Ribble Valley Borough Council
By email

Your ref: 3/2024/0170
Our ref: DC/24/730
Date: 13-MAR-24

Location: Brentwood Pendleton Road Wiswell BB7 9BZ
Proposal: Permission in principle application for one new dwelling.

Client: Mr D Higgins		
Project: Proposed Dwelling Brentwood Pendleton Road Wiswell		
Dwg title: Proposed Site Plan		
Scale @ A1: 1:500	Date: 16.10.23	Drawn by: PD
Drawing no. 1473 - 102	Rev. -

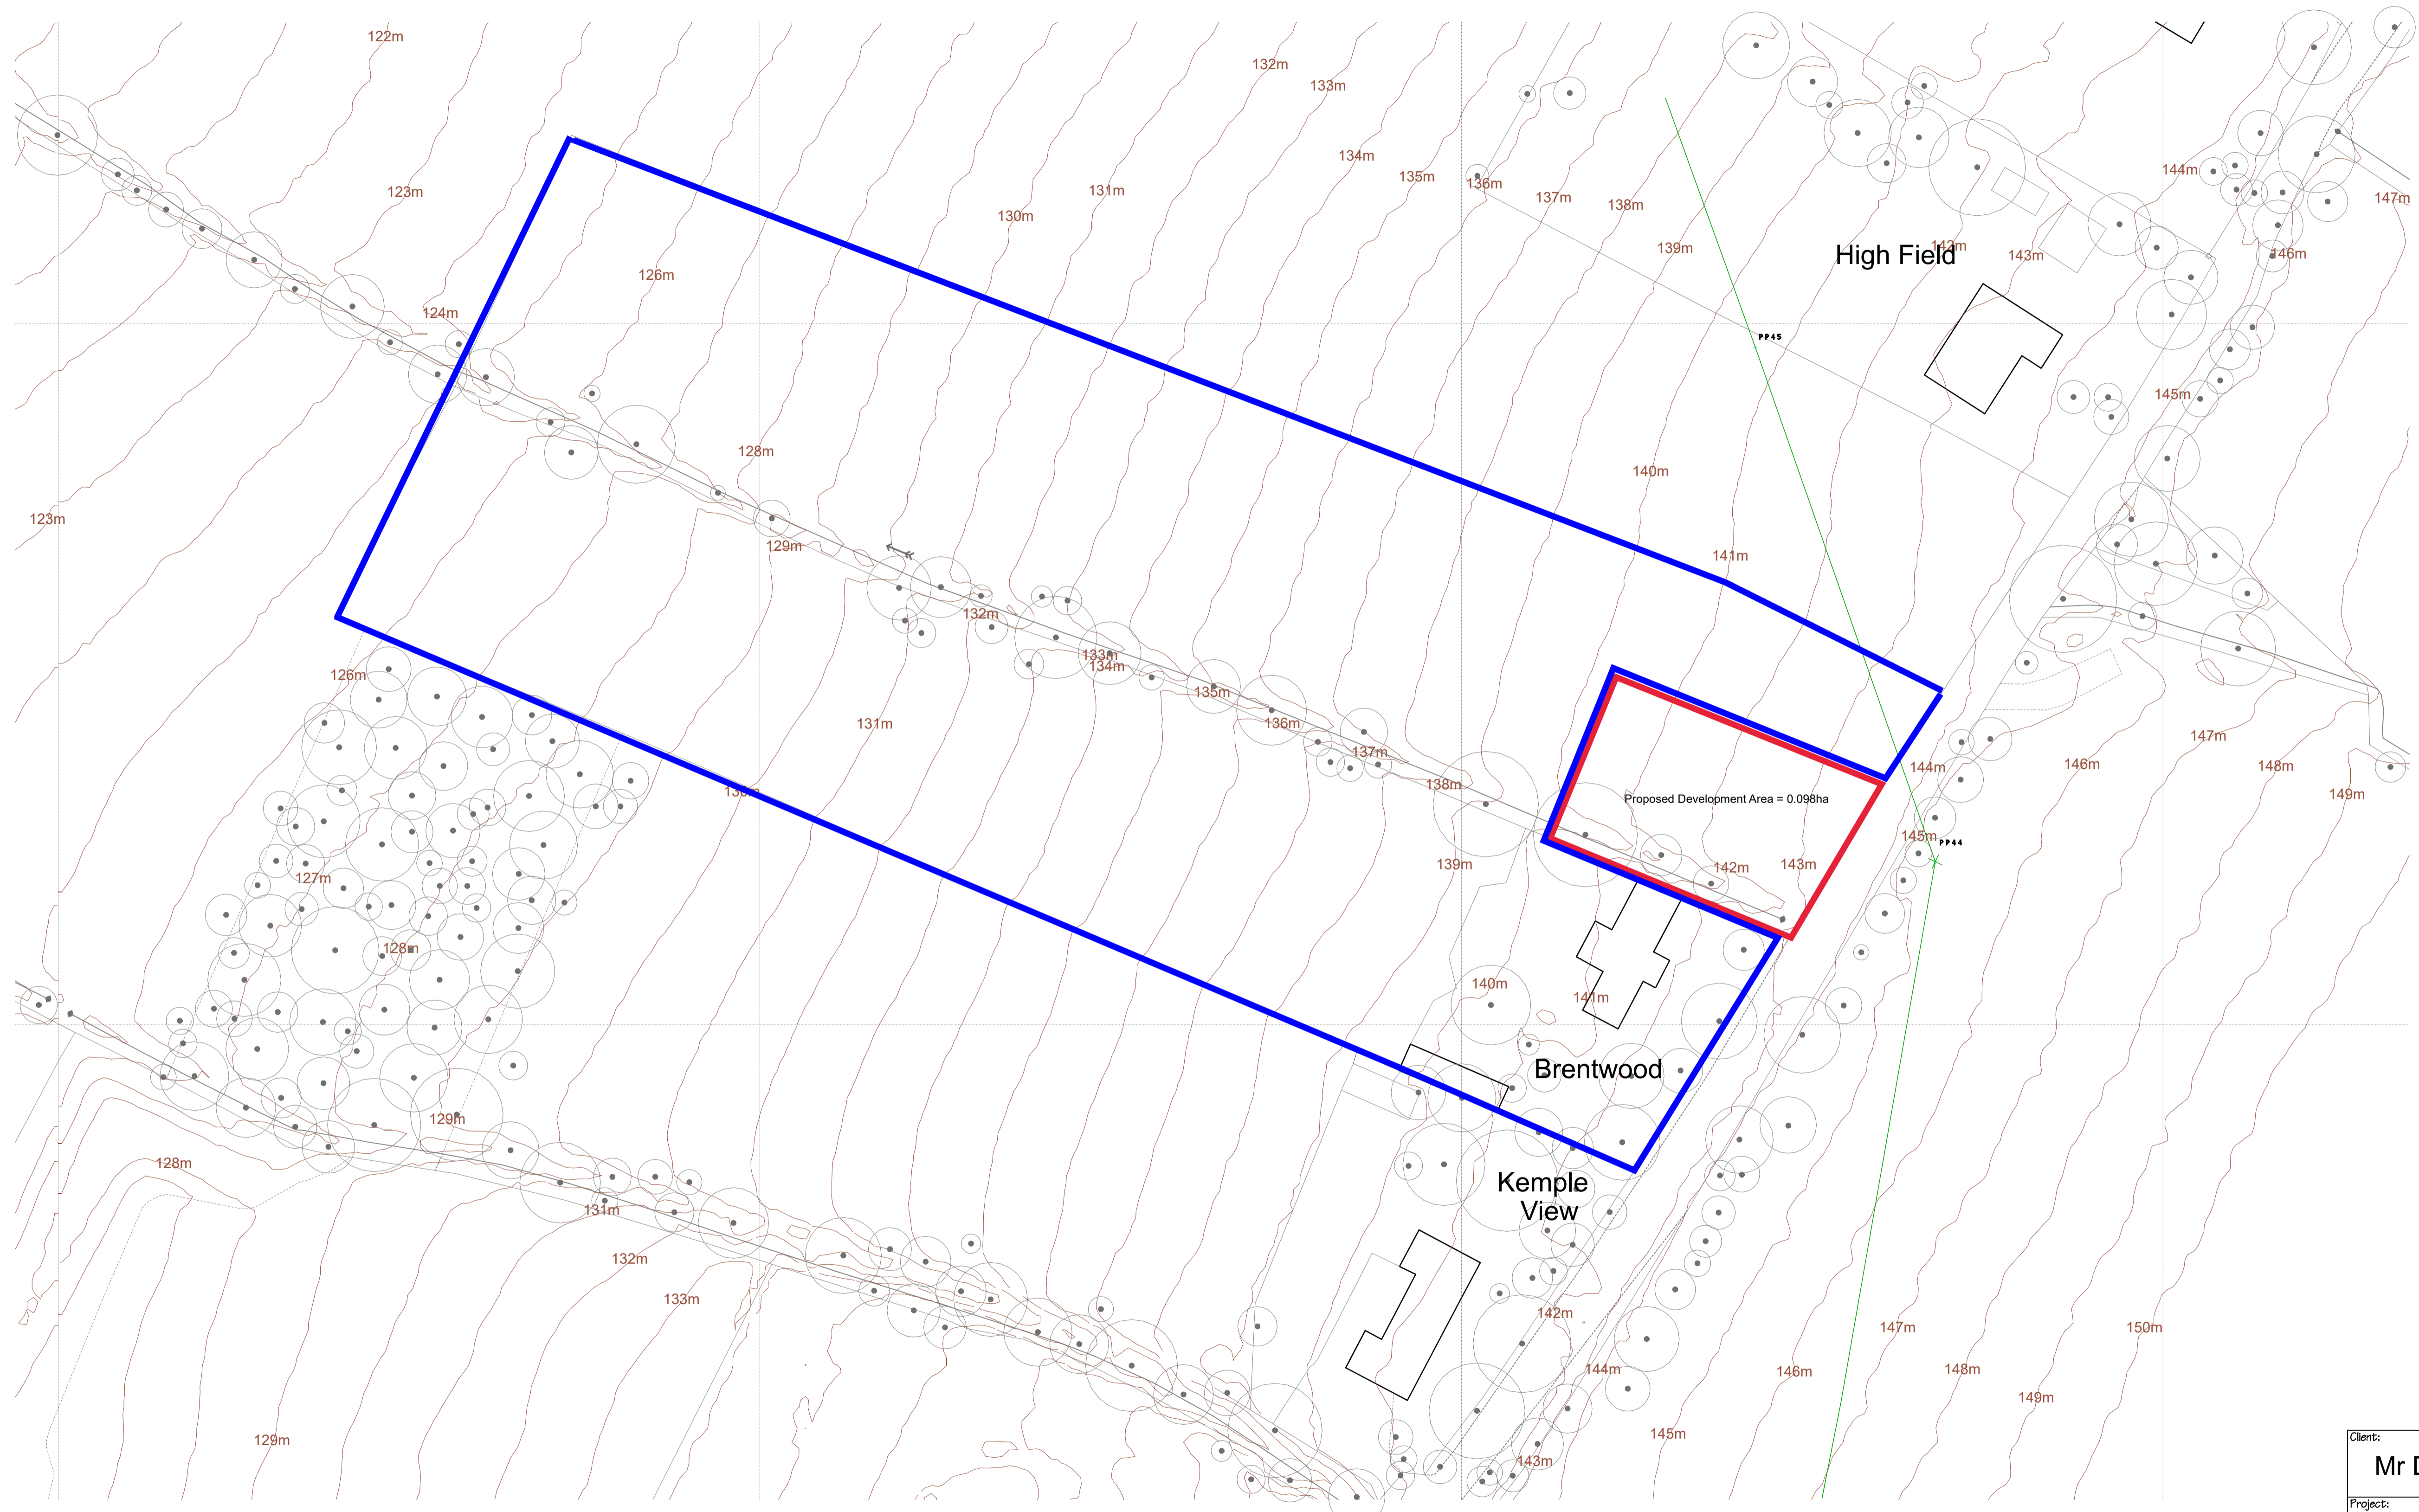
A water main crosses the site. It must not be built over, or our access to the pipeline compromised in any way. We require an access strip as detailed in our 'Standard Conditions for Works Adjacent to Pipelines', which can be found on our website: <https://www.unitedutilities.com/builders-developers/your-development/planning/building-over-or-working-near-our-assets/working-near-our-pipes/>. The applicant must comply with this document to ensure pipelines are adequately protected both during and after the construction period.

Based on the information currently available, it is unclear whether sufficient distance is provided between proposed development features and our water asset(s). We recommend the applicant contacts our Water Developer Services team to ensure existing water assets, along with our required access widths, can be accommodated in the proposed layout. If the applicant fails to investigate and resolve any concerns prior to a positive determination, there is a risk that as the scheme progresses, the applicant, or any subsequent developer, may discover that their plans are not implementable in their existing form or that diversion of assets is required. If the Local Authority requires any additional comment on the acceptability of the proposed layout from United Utilities, we will require a detailed site layout plan, which overlays the PROVEN location of the water asset(s) in relation to any proposed development (including walls, fencing, parking etc.).
